From: Andre Vernez <Andre.Vernez@shoalhaven.nsw.gov.au>
Sent: Monday, 12 December 2016 9:46 AM
To: Deana Burn
Subject: Shoalhaven Starches Modifications 10 & 11 - Flour Mill 'B' & Dryers, Cooling Towers, Maintenance Building & Biofilters - COMMENTS FROM SHOALHAVEN CITY COUNCIL
Attachments: SW DA Notice - 3A07-1008 - N4 (MOD 10 & 11).pdf
Follow Up Flag: Flag for follow up
Flag Status: Flagged

Please find below comments from Shoalhaven City Council in relation to Shoalhaven Starches Modification No. 10 (Flour Mill 'B') and 11 (Dryers, Cooling Towers, Maintenance Building & Biofilters). In summary, Council has no objection in principle subject to the following advice being considered. Comments have been segregated relating to the relevant sections of Council.

MANILDRA GROUP.NOWRA.
	FORKLIFT MAINTENANCE BUILDING. BUILDING DETAIL.

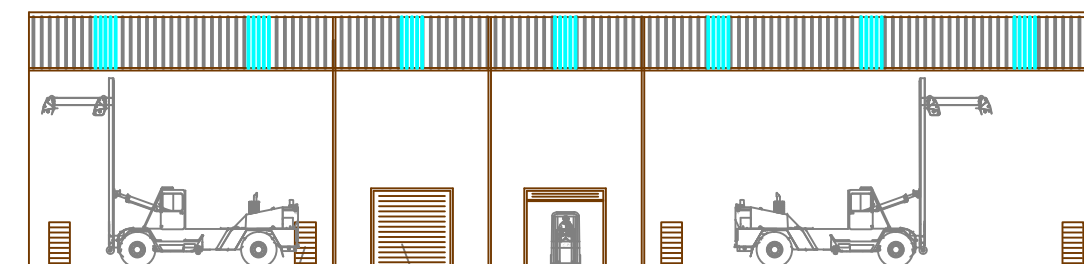
3. Written clarification as to how the coal and woodchips at the storage area at Hanigans Lane will not become debris during a flood event.
4. The floor levels for the MCC room, Forklift maintenance building and DDG Dryers need to be raised to at or above the FPL (6.3m AHD), unless the structures are sealed up to the FPL.
5. An appropriate consulting Engineers report to demonstrate that the buildings including the silos will not become floating debris during a 0.2% AEP flooding scenario. This report can be provided prior to construction.

FIGURE 6
PEAK FLOOD LEVEL IMPACT
1% AEP EVENT
SCENARIO C PROPOSAL AS PER PLAN

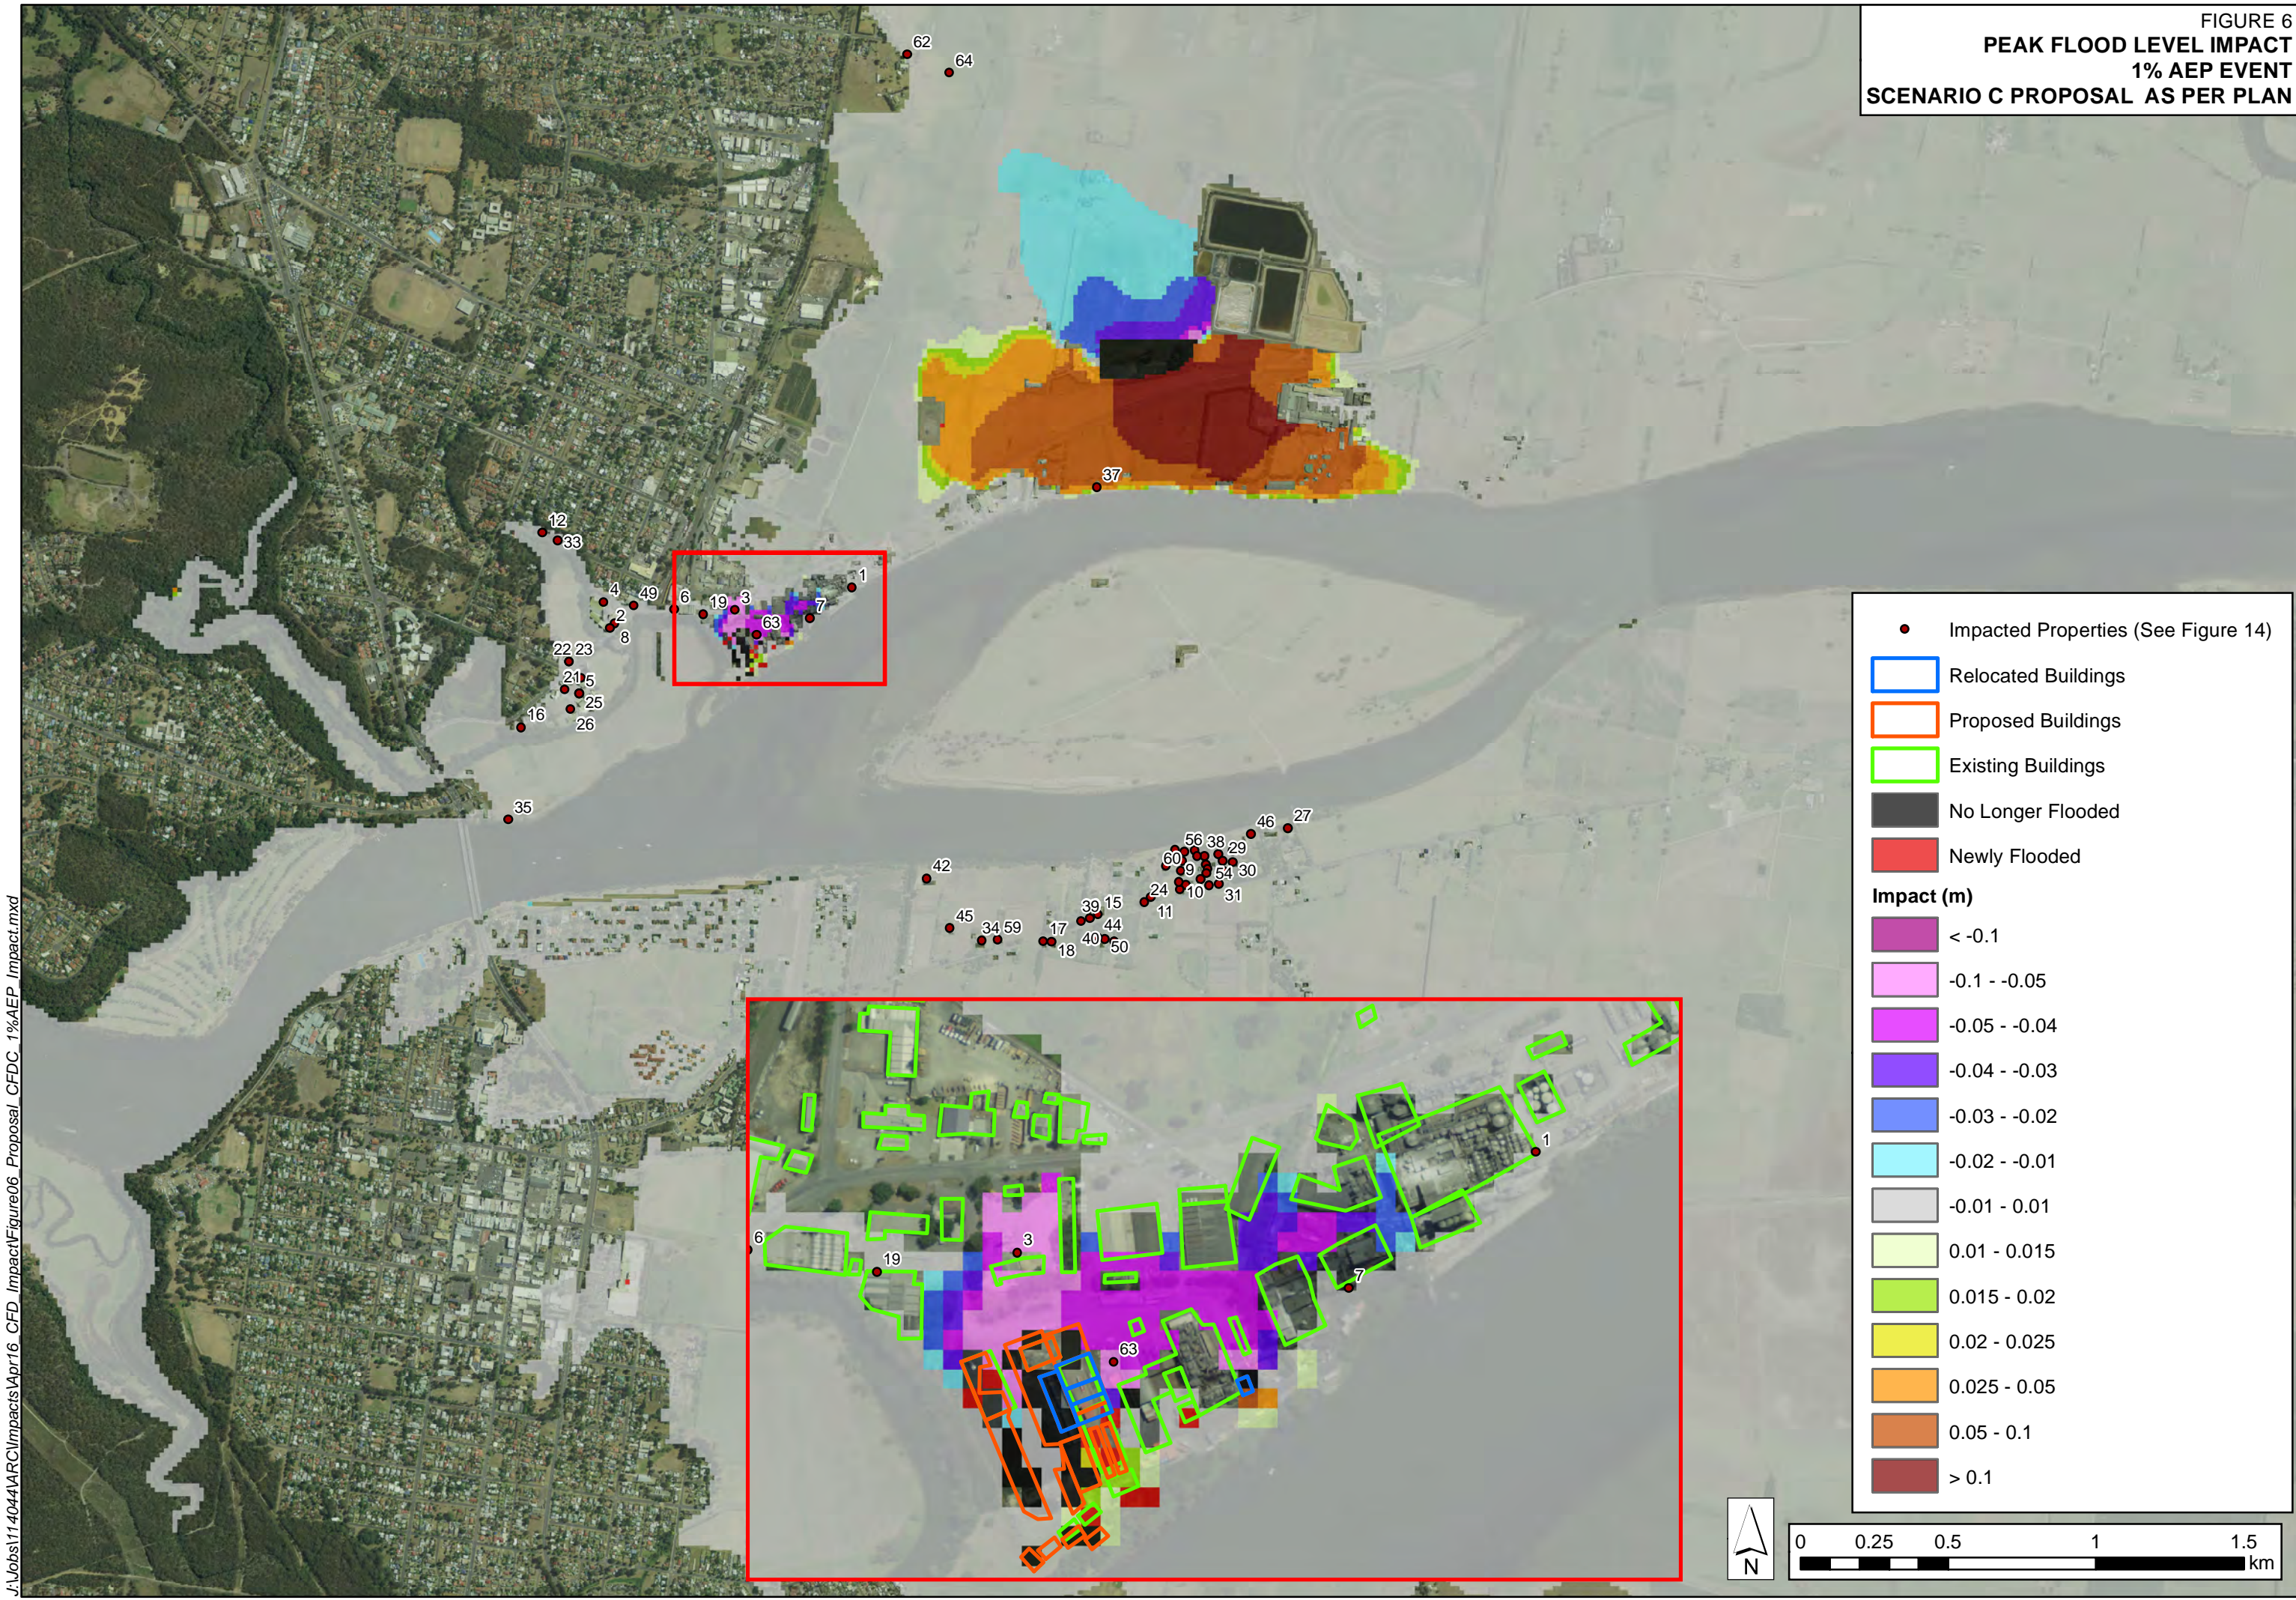
1. Further investigation into Scenario C in the Flood Impact Assessment Report to suggest an alternative way to minimise the hydraulic impacts. The Flood Impact Assessment Report shows that Scenario C for the Coal and Woodchip storage area at Hanigans Lane may produce over a 0.1m increase in the flood level on the south side of the proposed development and may increase the velocity significantly at Bolong Road, which in turn may affect private properties.
2. Written clarification as to how the emergency coal and woodchip storage area will be utilised if the road is inundated, given Bolong Road being inundated during frequent flood events.
